Our ref: NO/2012/103772/01-L01

Date: 07 June 2012

**PROPOSED NEW SLURRY LAGOON
WITHGILL FARM, WITHGILL FOLD, WITHGILL, CLITHEROE**

PROPOSED SITE PLAN

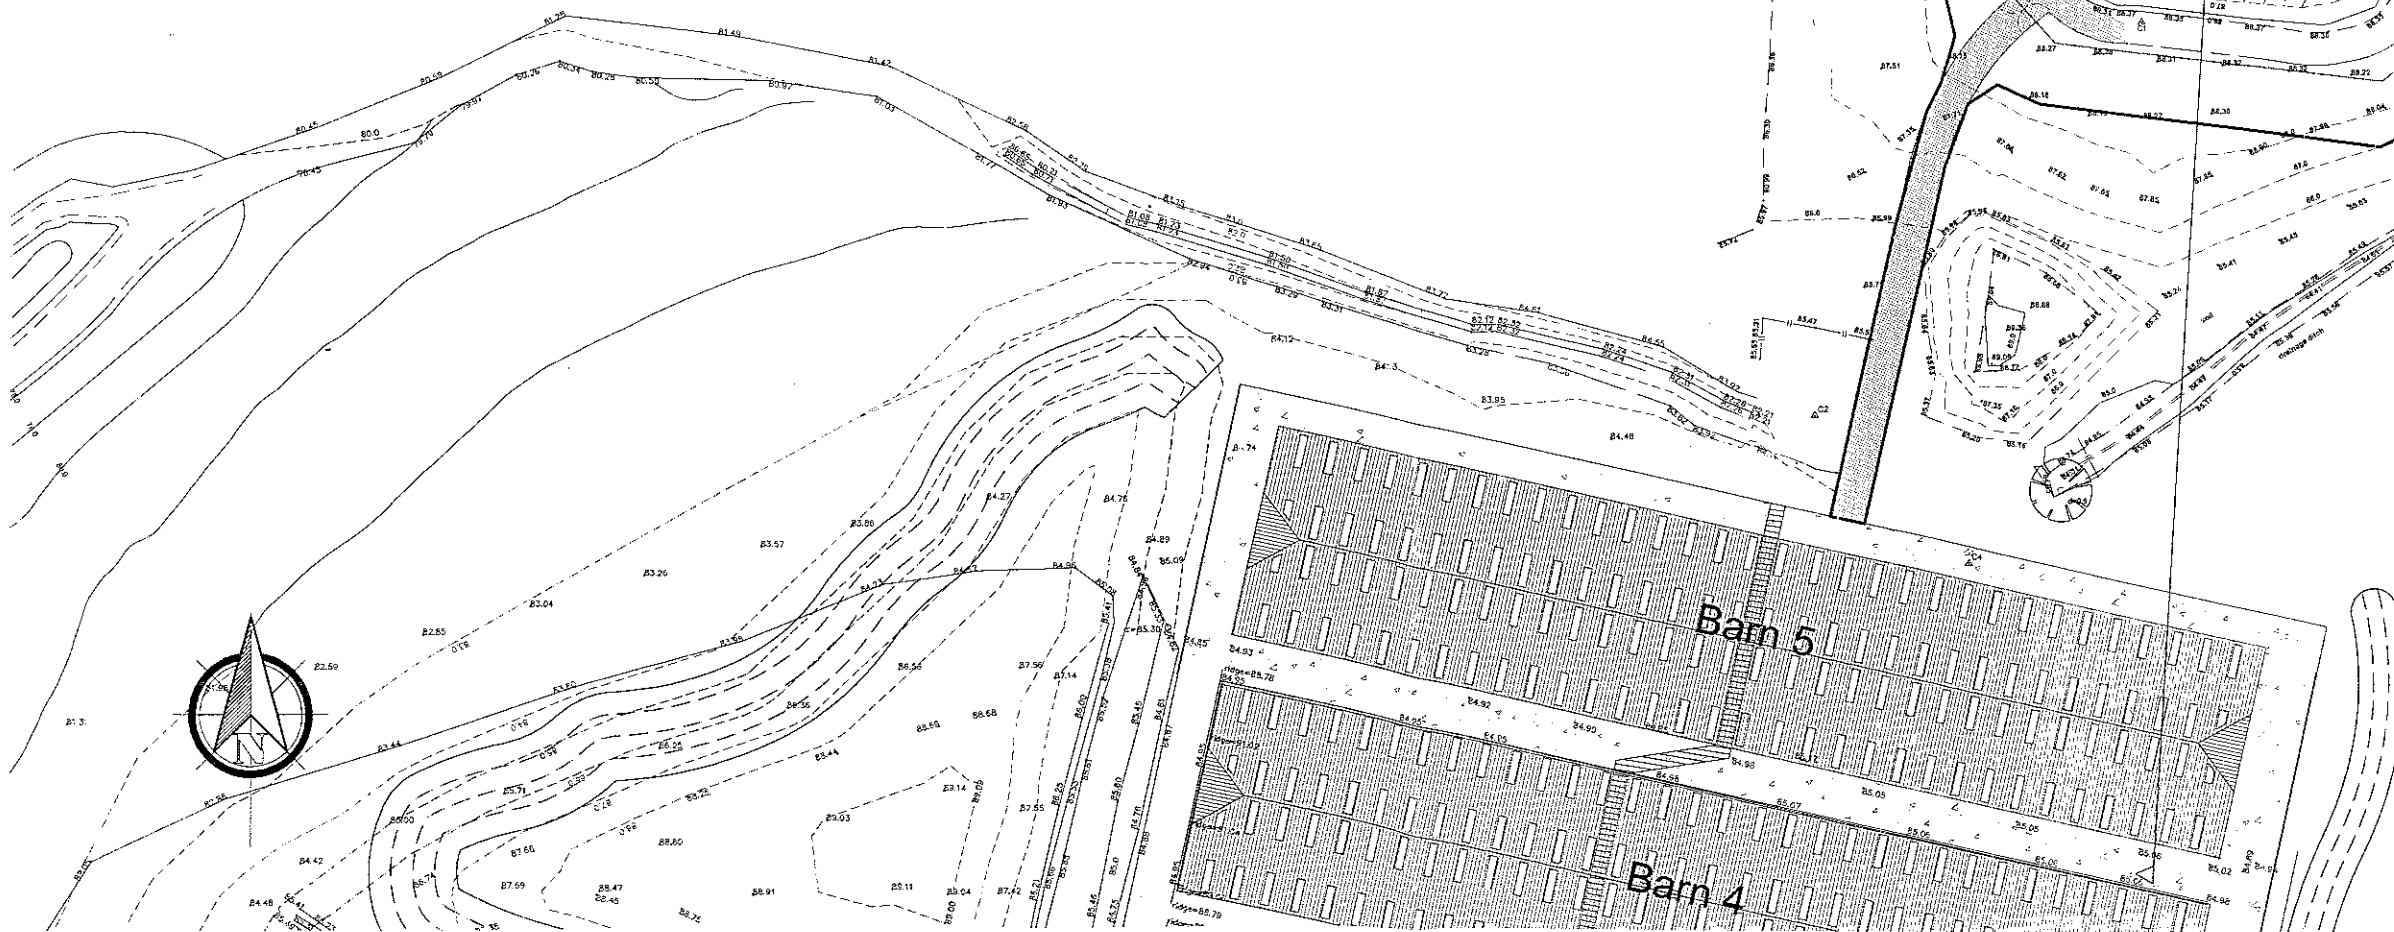
In this case we consider that the proposed development may pose an unacceptable risk of causing a detrimental impact to groundwater quality because the suitability of this site for an unlined lagoon depends on the nature of the drift deposits that are present

This is an objection in detail. The applicant should provide the Local Planning Authority with soil permeability test results as the suitability of this site for an unlined lagoon depends on the nature of the drift deposits that are present.

Results will need to include an indication that there is at least 1metre of suitably low permeability material at the base of the lagoon.
